Our Ref: EN010117

### **Proposed Application by Rampion Extension Development Limited for an Order Granting Development Consent for the scheme Rampion 2 Offshore Wind Farm – EN010117**

#### **Advice following issue of decision to accept the application for examination**

VER	DATE	REMARKS	DRAW	CHEK	APRD
01	14/09/2023	DRAFT	LB	NC	UP
02	15/09/2023	FINAL	LB	NC	UP

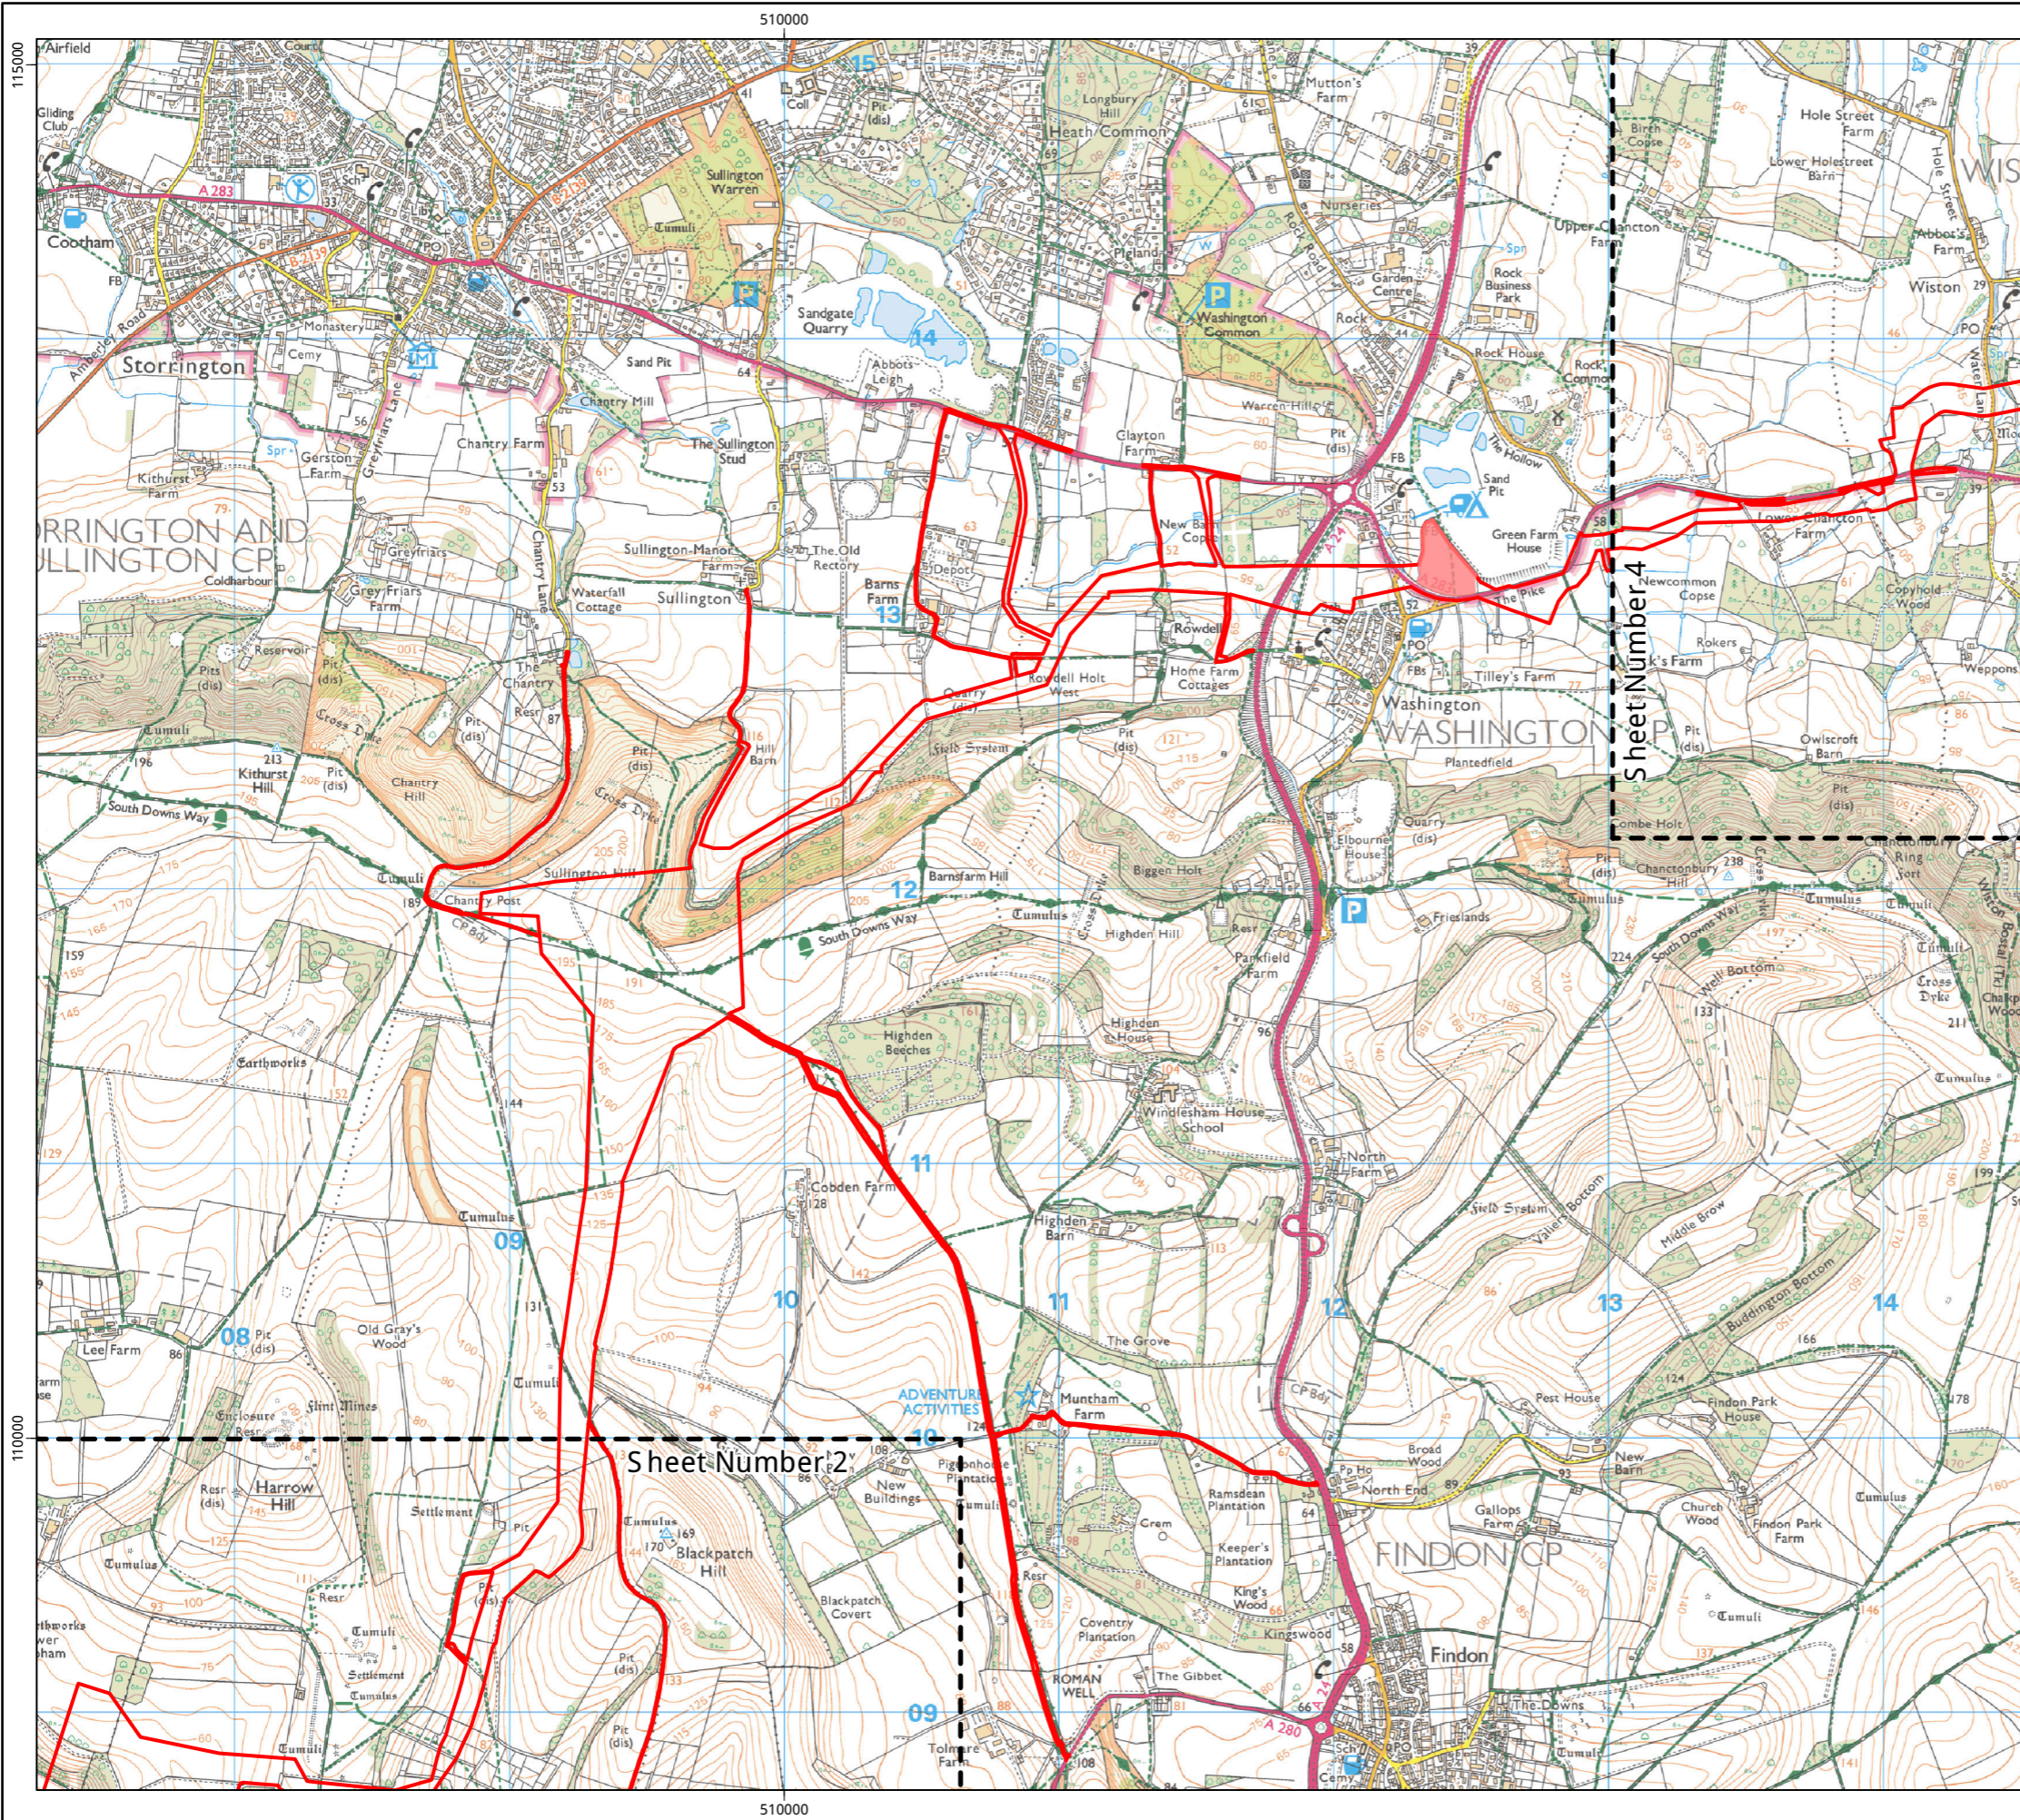
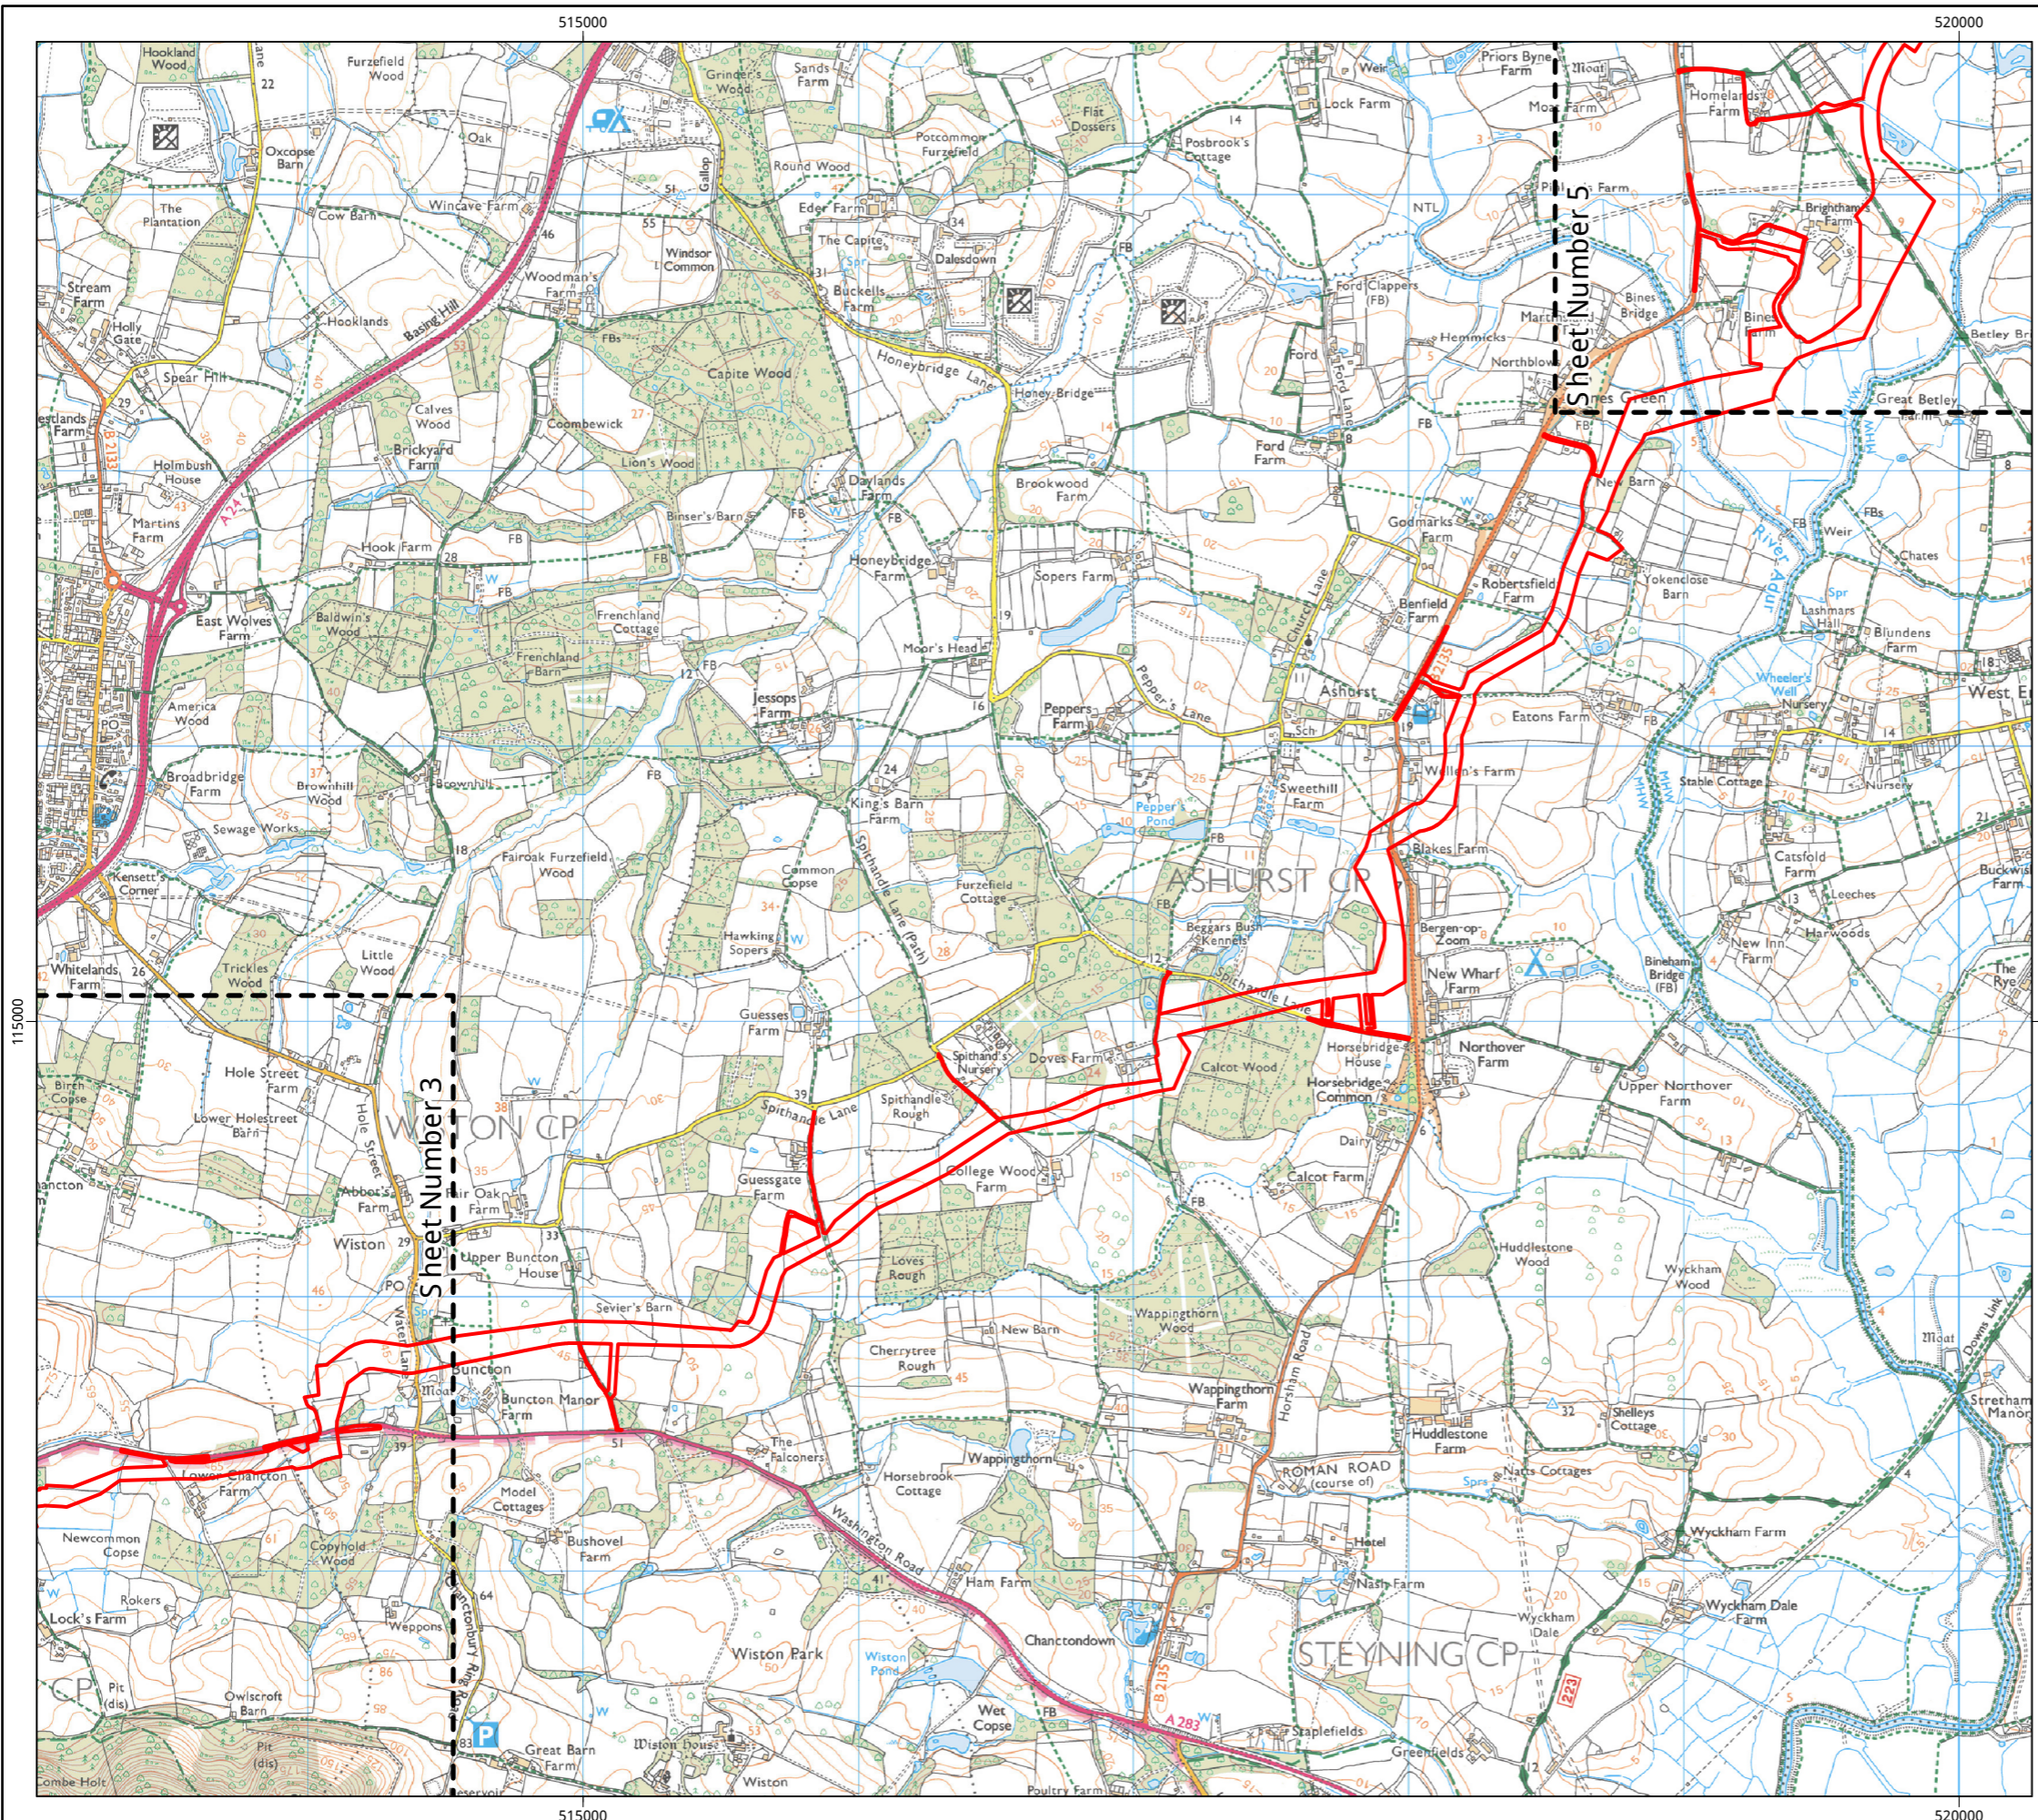
The Inspectorate notes there are no Onshore General Scheme Outline Plans. It is advised that such plans are submitted and that they clearly show arrangements of onshore cable routes.
